Planning Inspectorate (the Drovers Solar
Farm)

Reference: OR-0009338/01
Customer reference: EN0110013

**Deadline 3 submissions response letter
The Drovers Solar Farm**

DRAWING TITLE:
Figure 12.13: Work No. 2 Maximum Potential Foundations and Groundwater Elevations

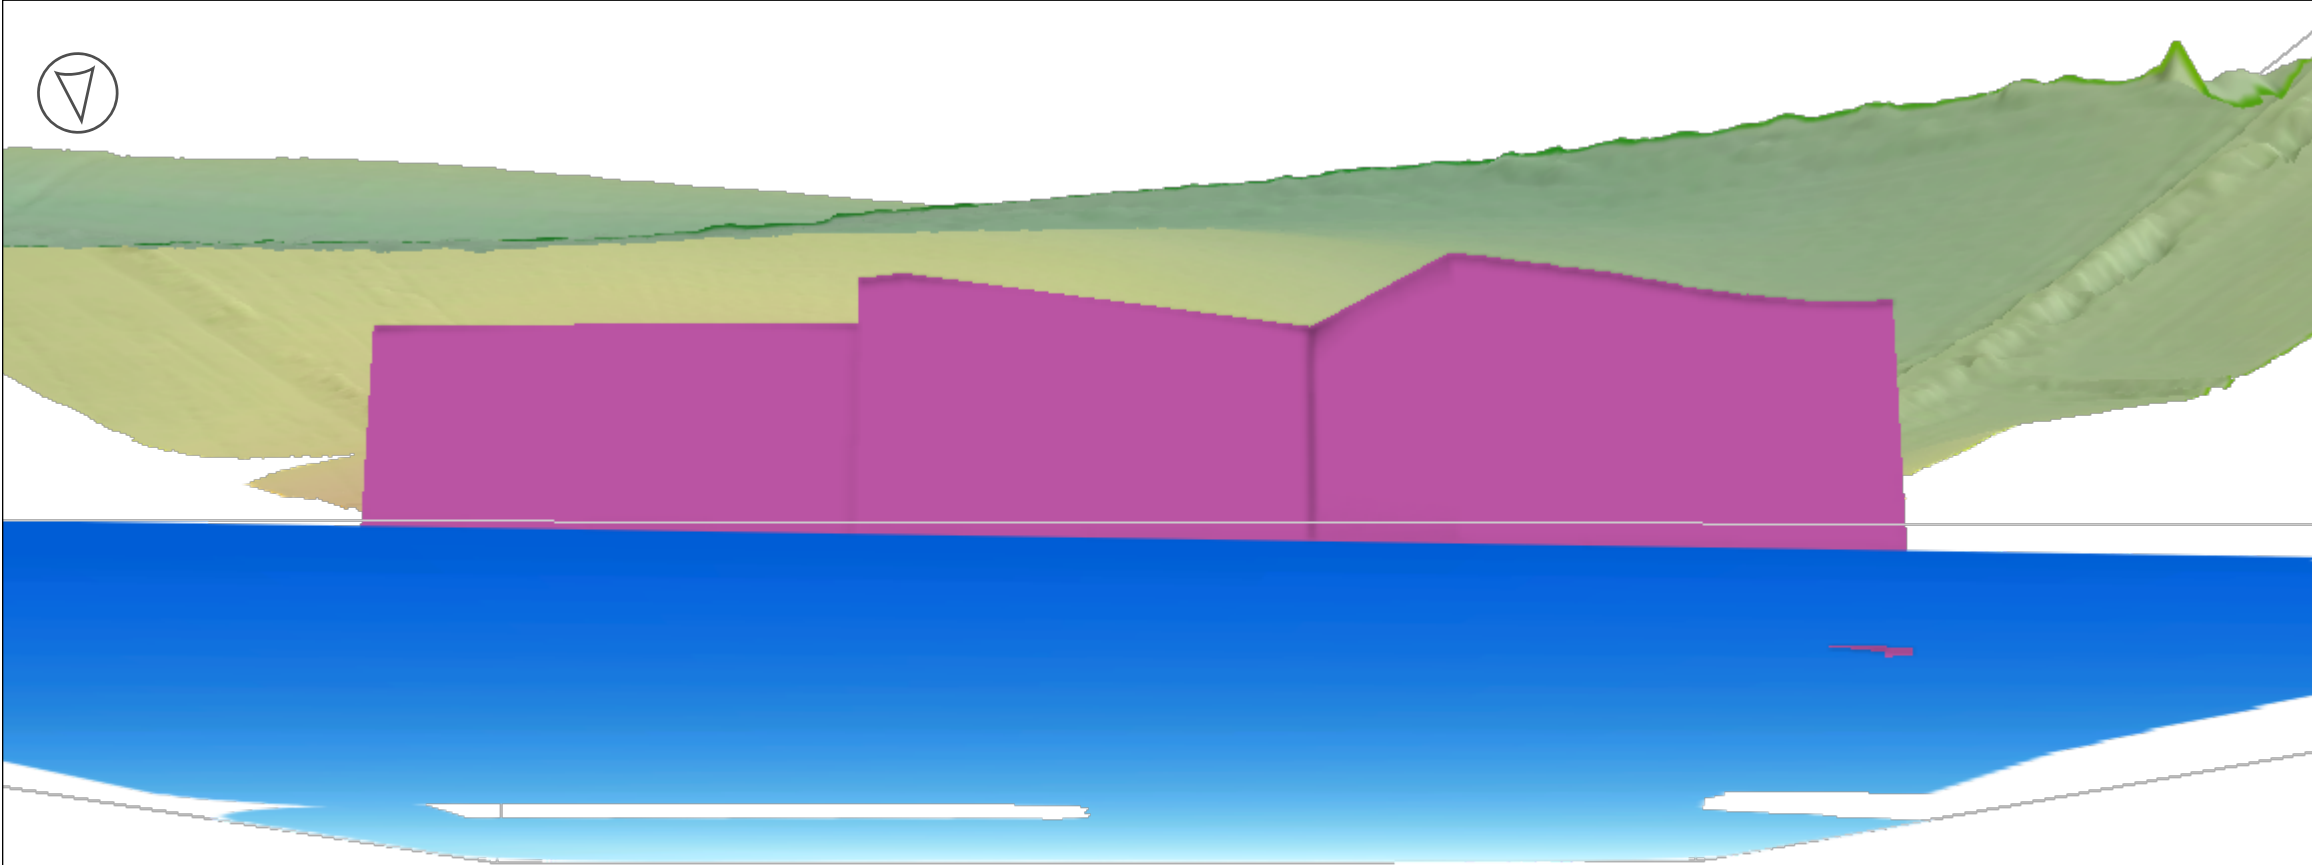
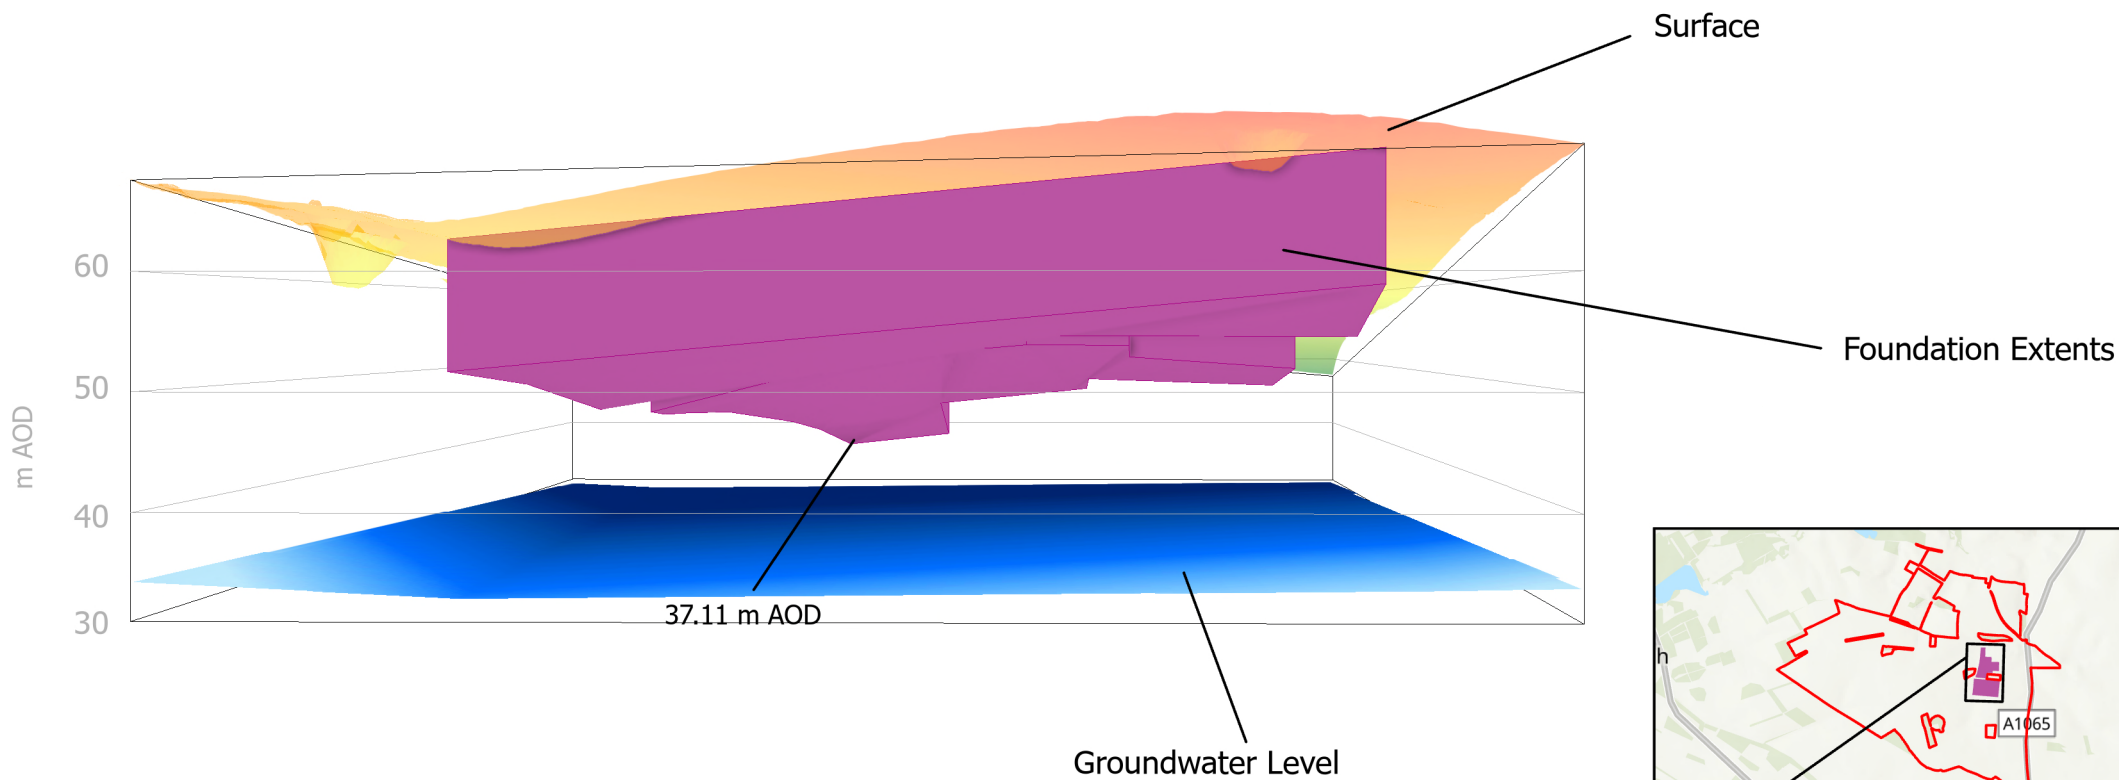
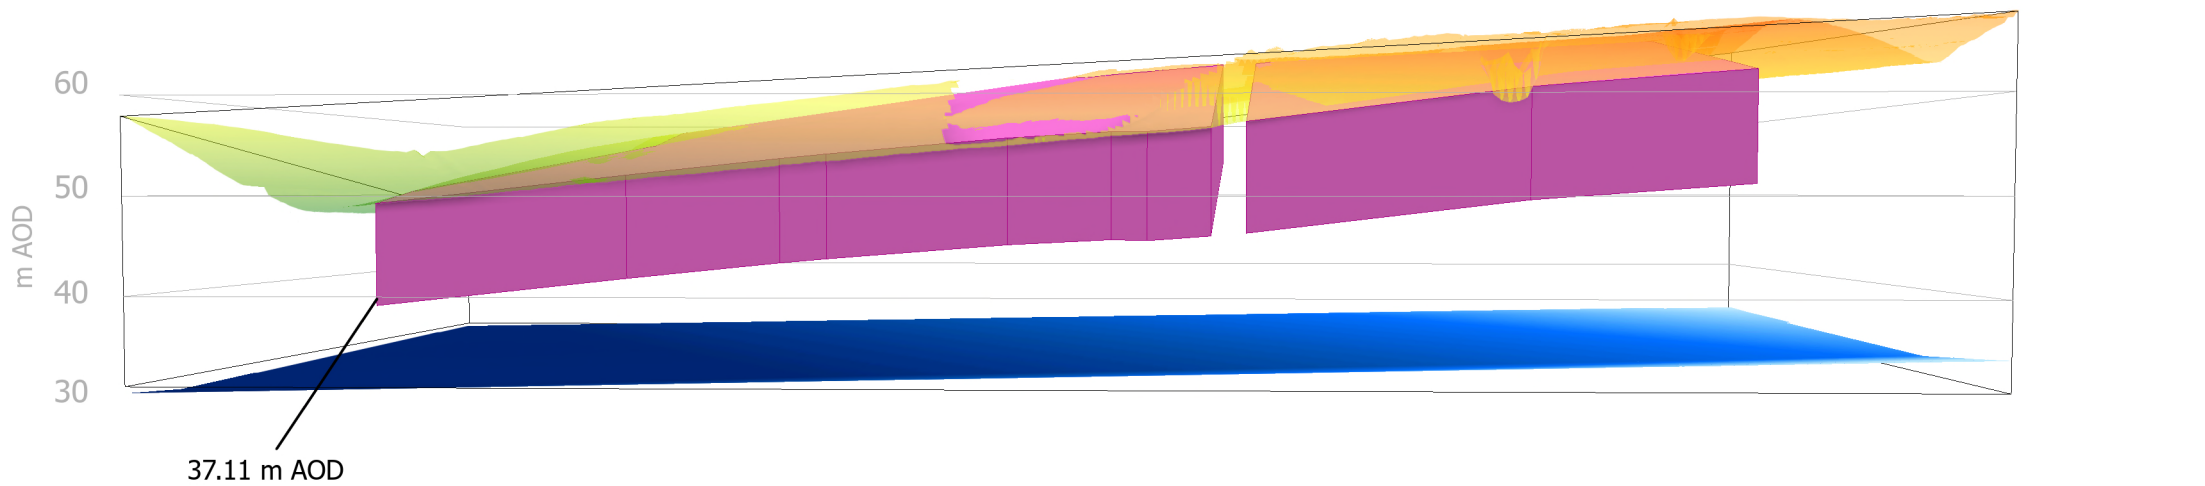
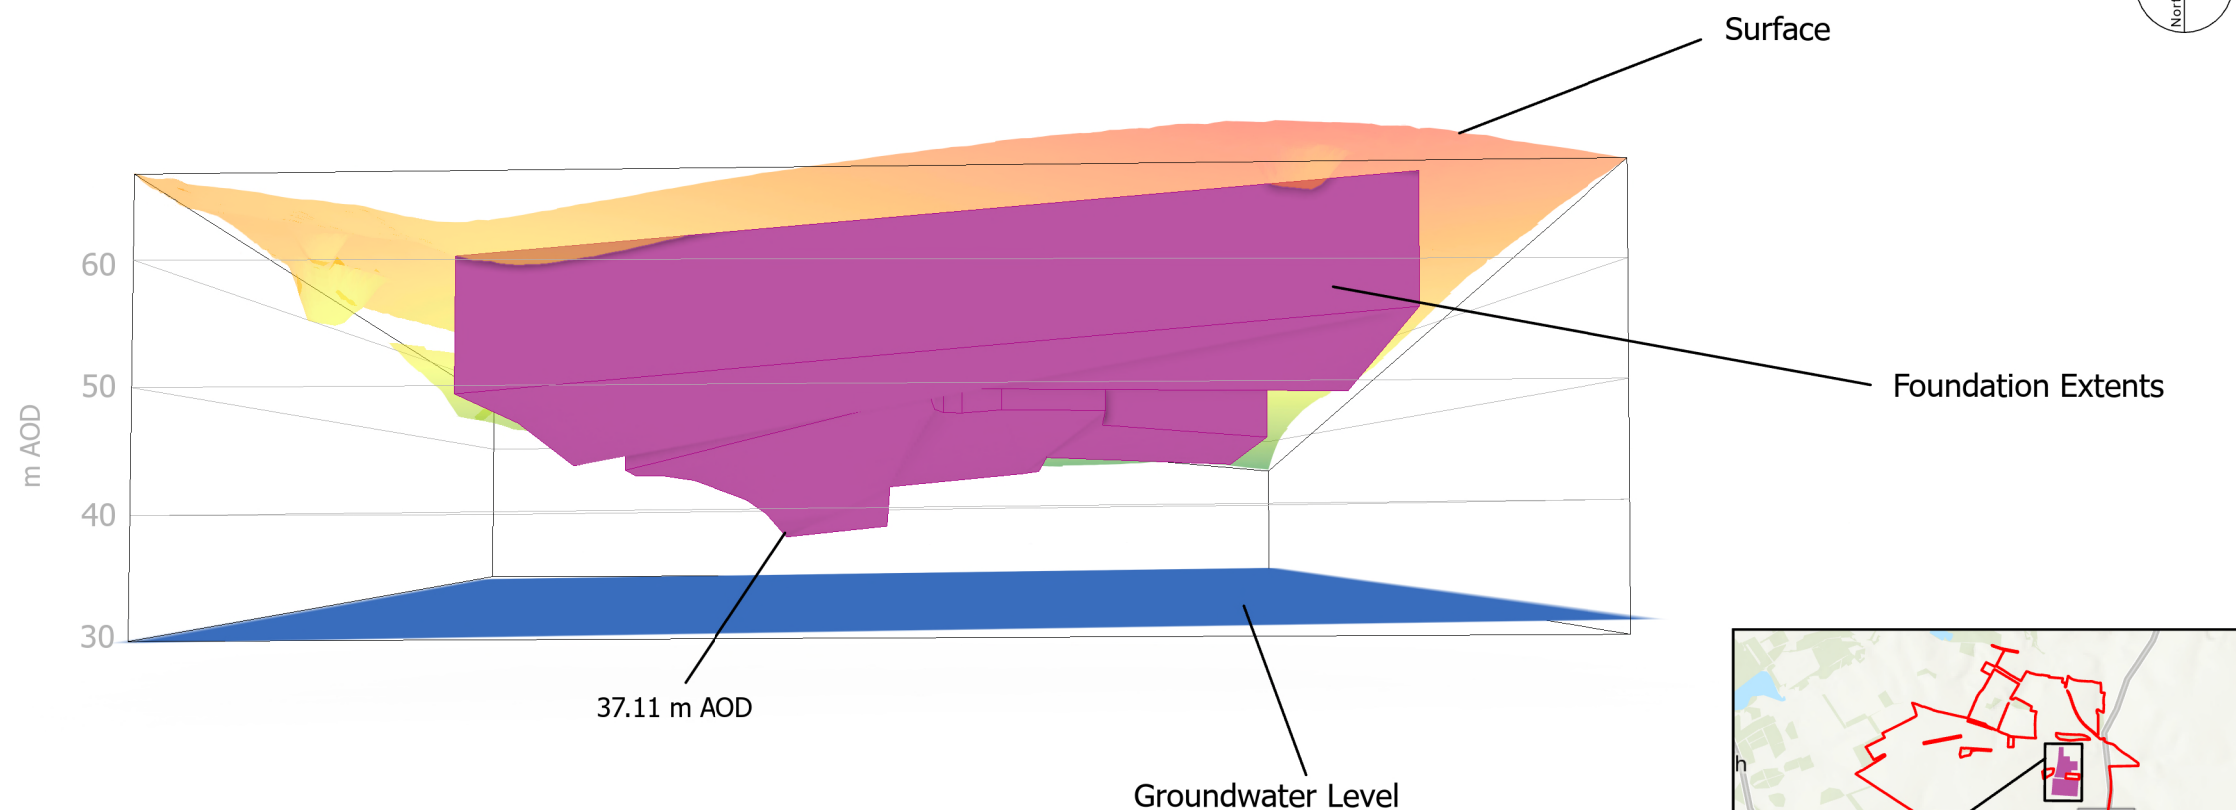
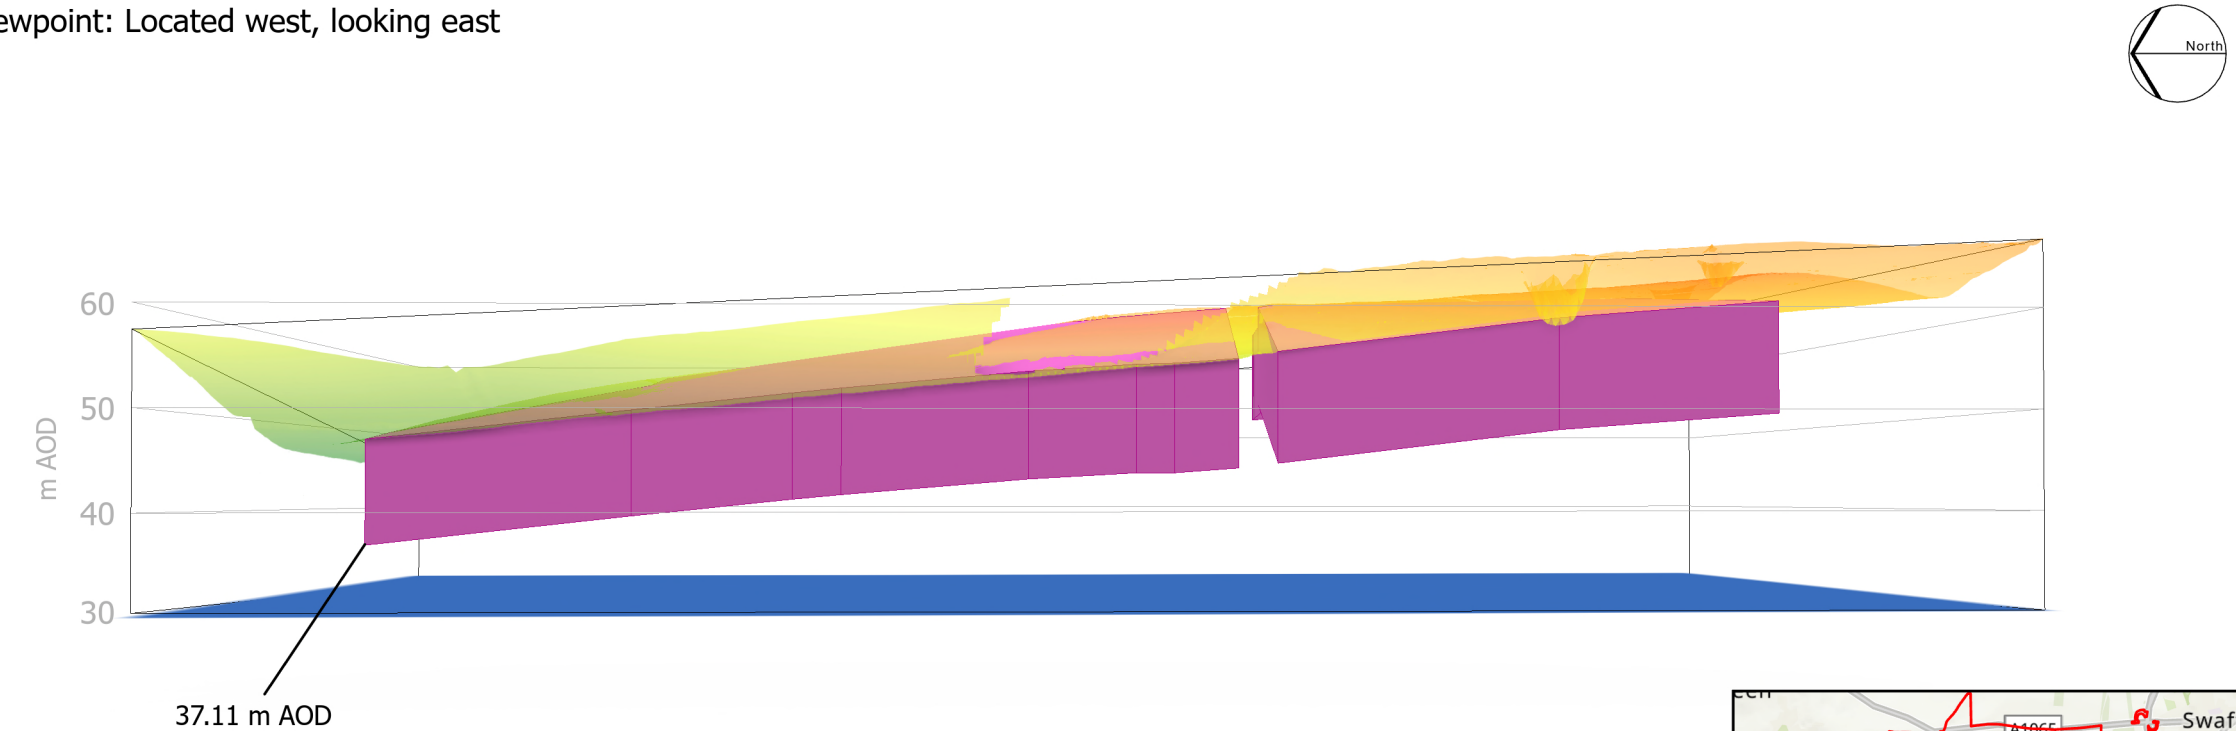
We were concerned that figures 12.13 [[APP-127](#)], 12.14 [[APP-128](#)], 12.15 [[APP-129](#)] and 12.16 [[APP-130](#)] do not clearly define the area represented by the drawings, including view orientation, or the elevation values.

- 6.3.1 ES Figure 12.13 Work No. 2 Maximum Potential Foundations and Groundwater Elevation [[REP3-043](#)]
- 6.3.1 ES Figure 12.14 Work No. 3 Maximum Potential Foundations and Groundwater Elevation [[REP3-044](#)]

We find the updated figures satisfactory for defining the 3D model view, and elevation the maximum extent of the foundations.
